SITE: 16 Murray Road, Northwood

Planning Ref: 4626/APP/2019/629

16 Murray Road – MOLA response to LPA's observations.

PROPOSED ROOF PLAN

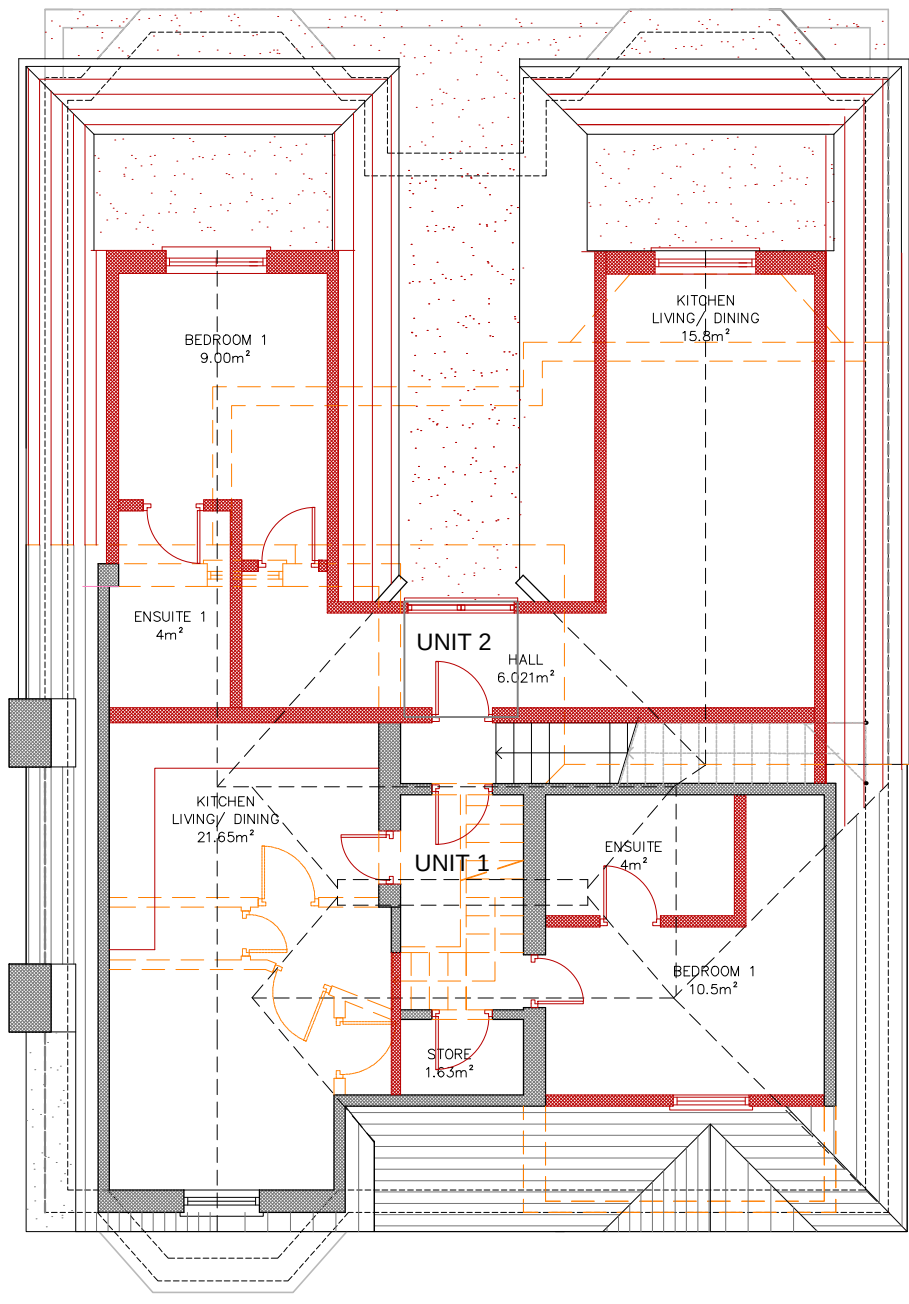
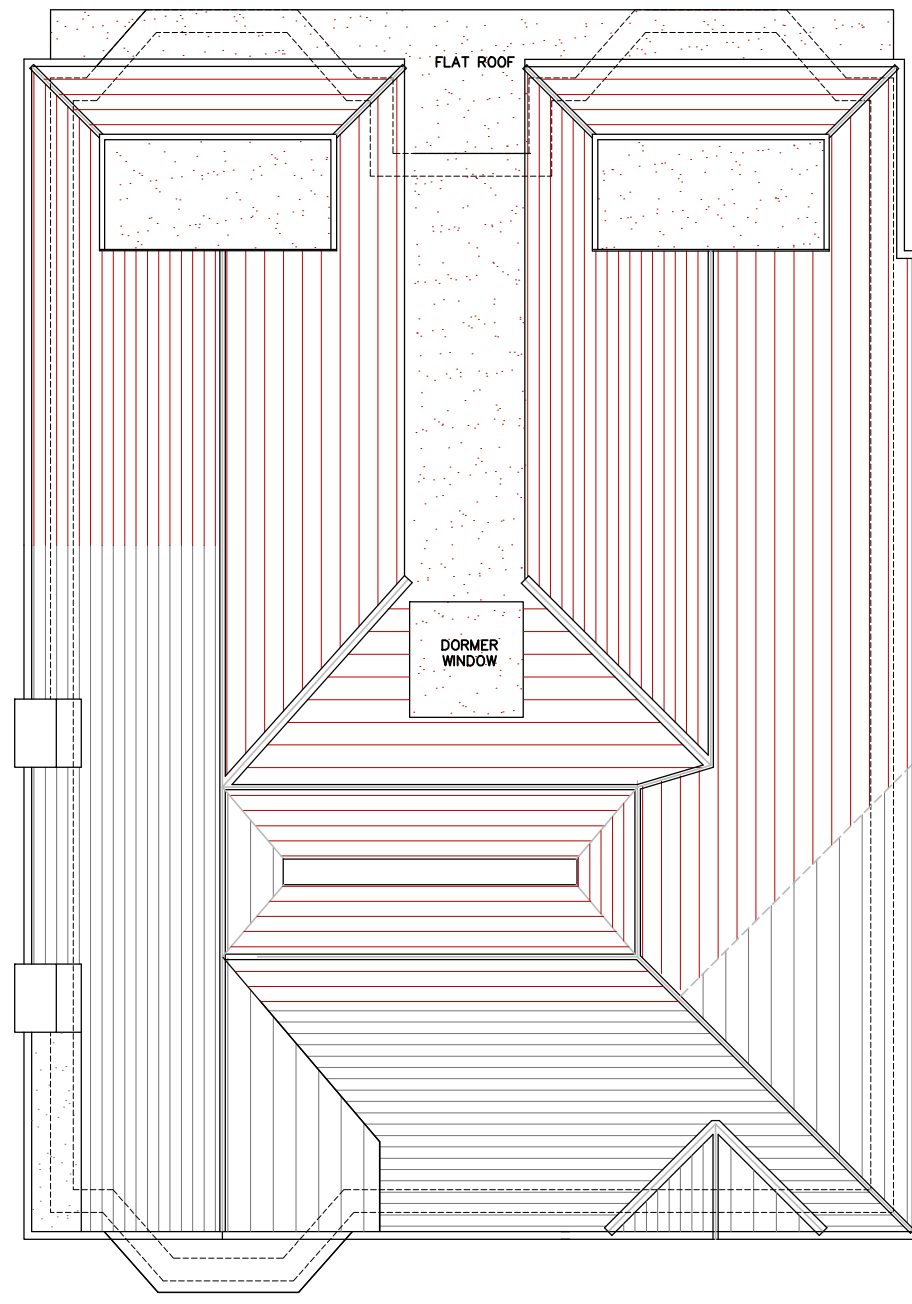
6. The gable ends are set back behind a flat crown roof in order to reduce the bulk of the rear extension. The fact that this is not a traditional roof design will only be visible from the side elevations or from above. The side elevations are not visible from the public domain.
7. The flat section of the current roof will be significantly smaller than the current existing one which is incongruous with the rest of the property. The new proposed roof will make the rear elevation look more symmetrical and will make the overall roof appearance more traditional than it currently is.
8. In order to mitigate perceived incongruity with the character of the Conservation Area, further revisions to the roof design to make it more aligned with traditional construction may be undertaken.

PROPOSED FRONT ELEVATION

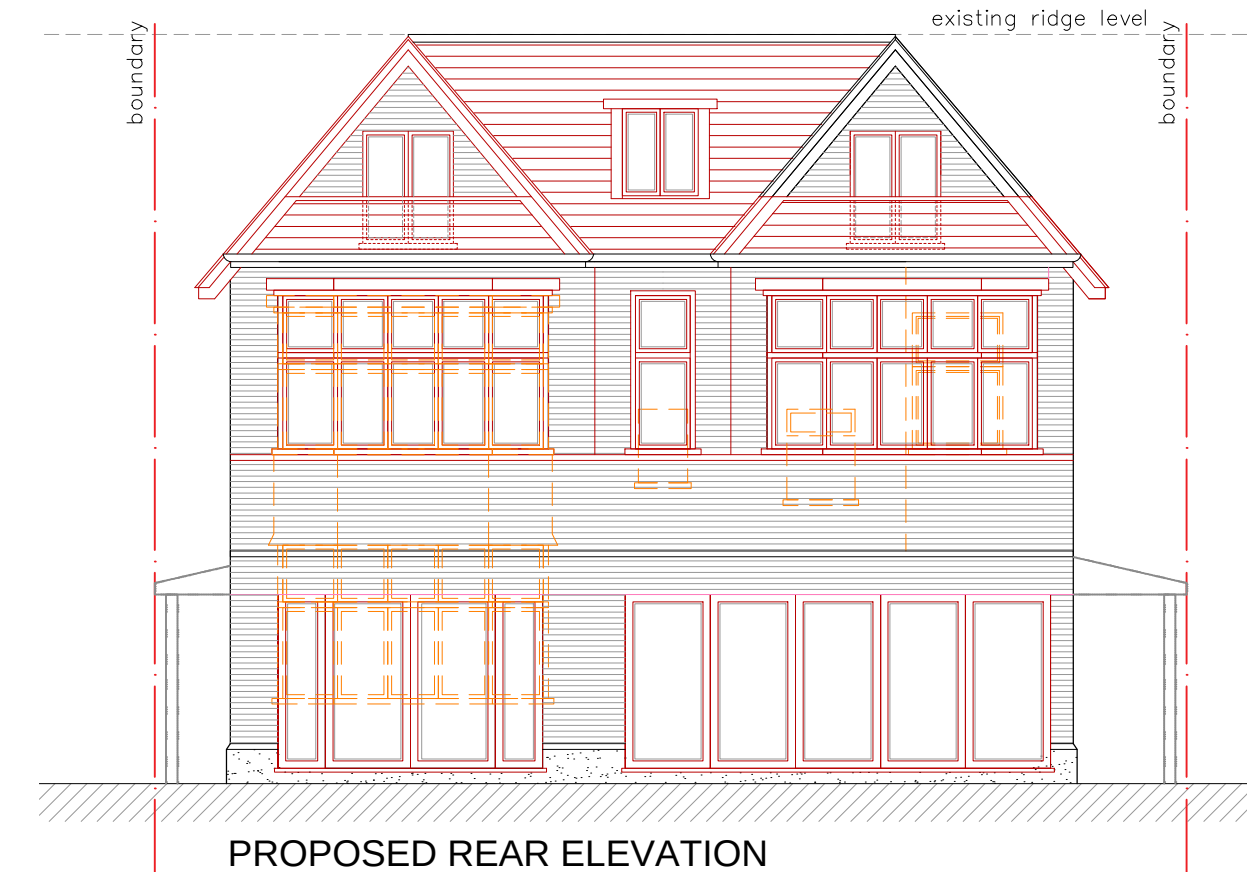
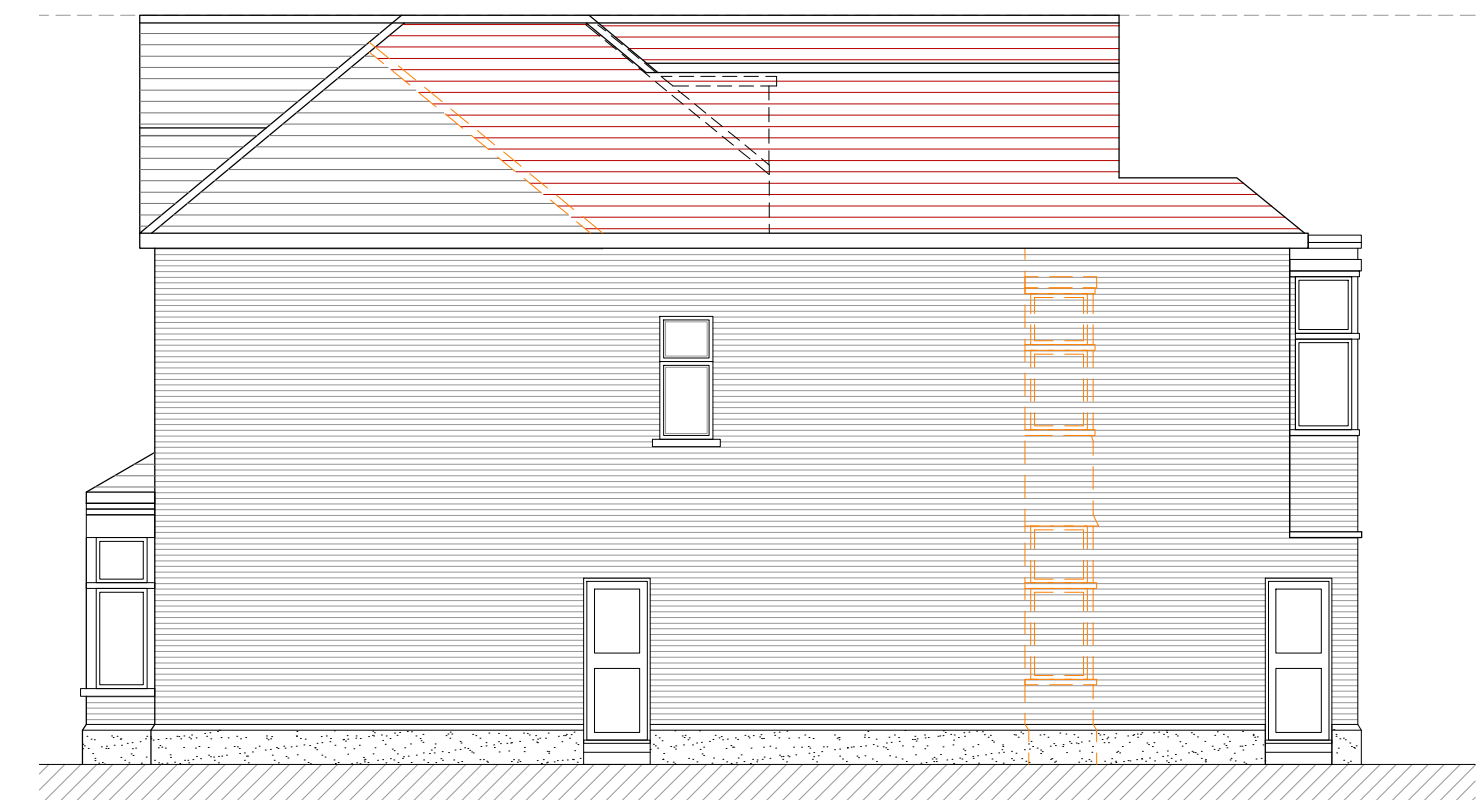
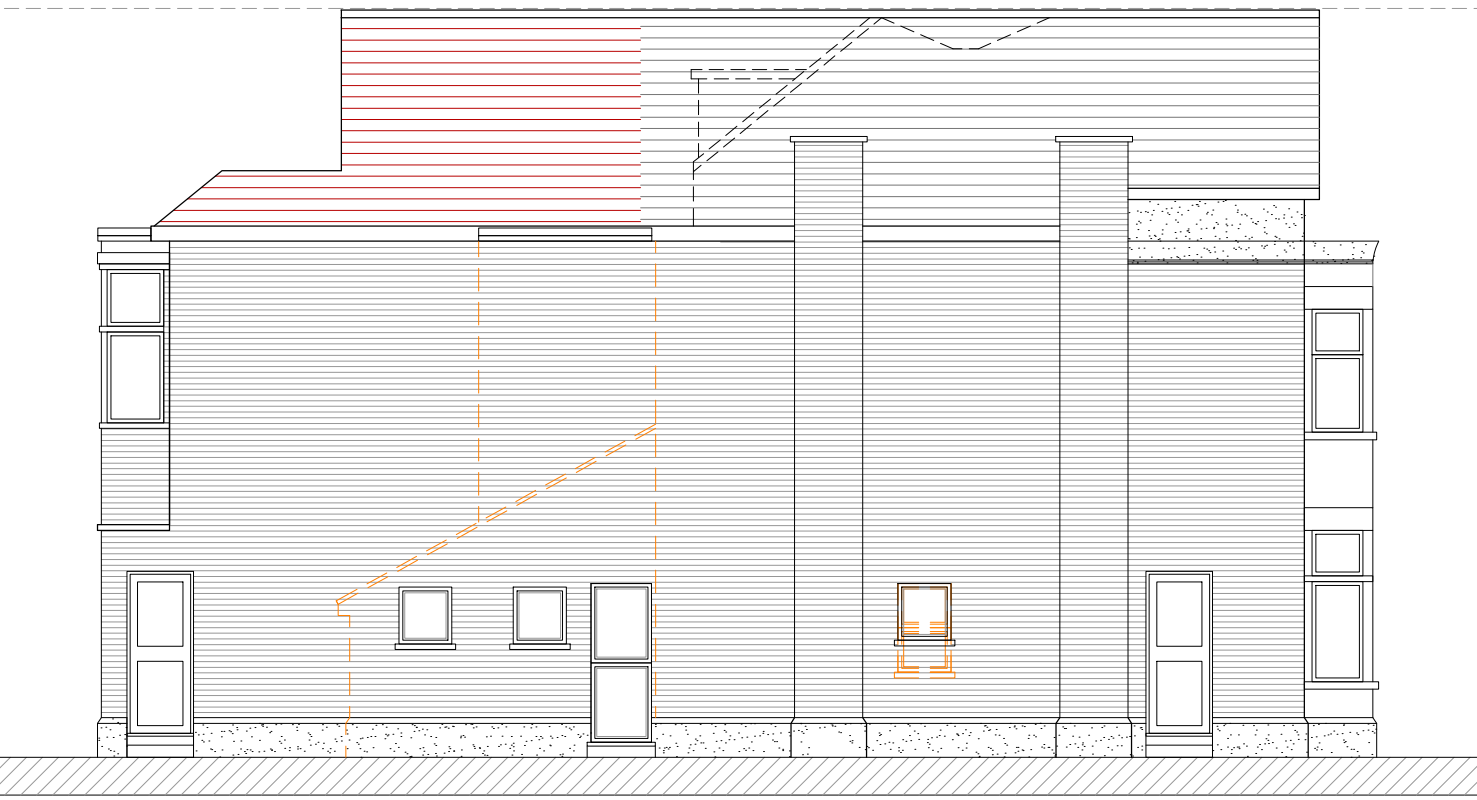
1. The LPA contends that the front elevation will be altered via roof remodelling to accommodate increased living space in the attic. This conclusion has been reached by looking at the side elevation to look at the roof lines. However, the proposed plans show that the front elevation does not change, any elevated roof height or change in layout behind the gables is not visible from the front elevation. The front elevation is not intended to be viewed from an oblique or side angle.
2. If there is an increase in roof height, this change is so slight that it is likely to be imperceptible to the naked eye and therefore will not affect the visual relationship of numbers 16, 18 and 20.
3. The Conservation Area appraisal and the observations by the LPA note that 16, 18 and 20 Murray Road form a group. Numbers 16 and 18 and retain their terracotta ridge tiles and

PROPOSED GROUND FLOOR PLAN

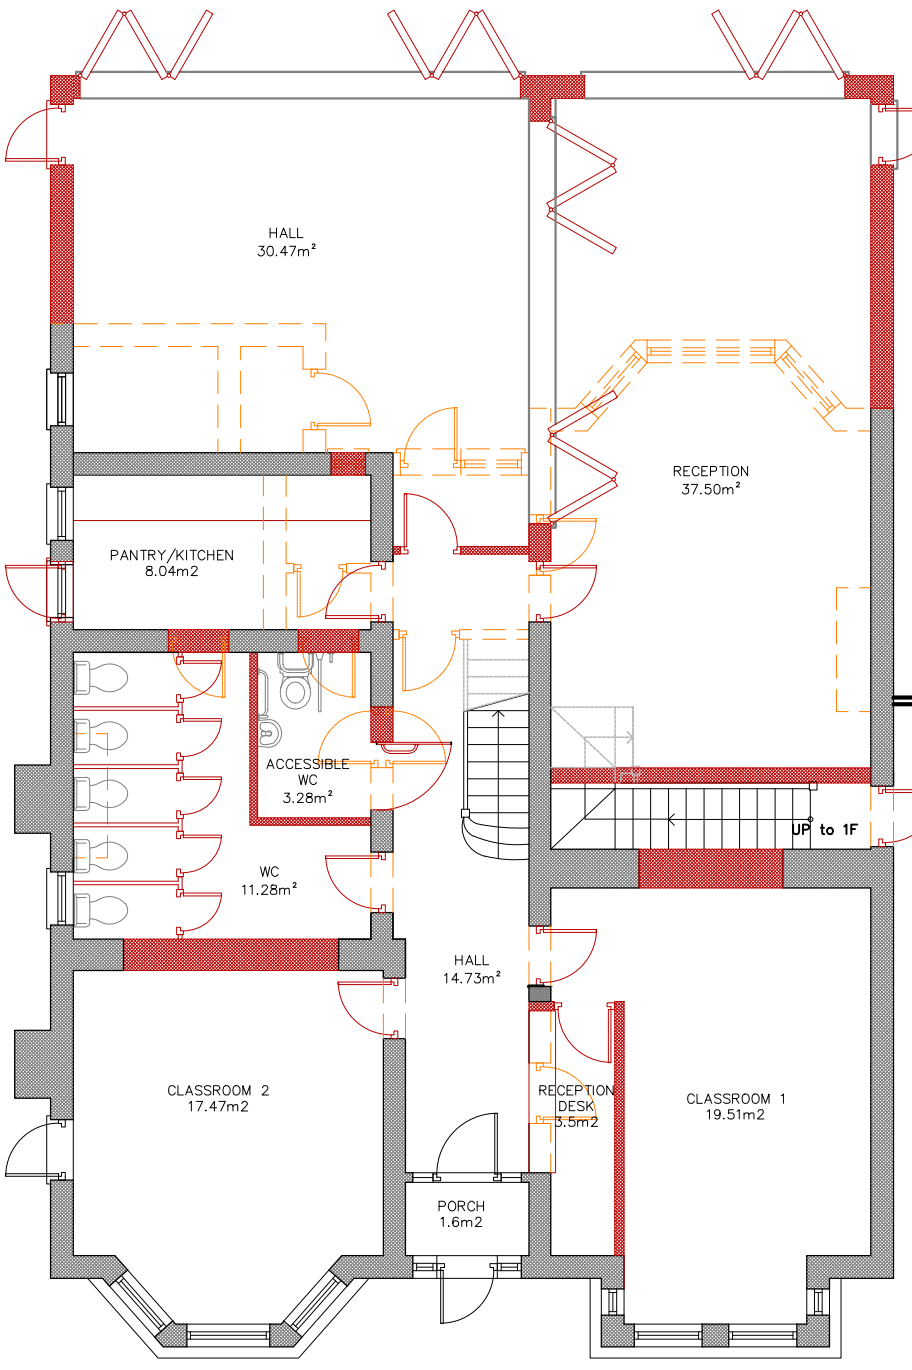
14. The LPA contends that the rear right hand room with bay window will be removed by the proposed extension. It will be removed by virtue of the fact that the extension is being demolished and replaced. This room is not original to the building as it is part of the later flat roof extension. The new room is not being sub-divided or joined with the front room to form an open plan style so it will remain as a principle room.

15. The left hand room at the rear on the ground floor is not being partitioned, this part of the building is being demolished to be replaced by the new extension. This will create two rooms and a portion of the hallway. Previously it encompassed a store, W.C and two small rooms. This change in layout is not substantial nor does it affect the flow inside the property.
16. The attic floor plan is not being entirely erased. It is being altered in line with the proposed rear extension. The rooms to the front elevation will remain in place, though their size changes slightly. The rooms to the rear are part of the new proposed extension.

A further amendment to the proposed plans could be made to suggest the retaining of bay windows.
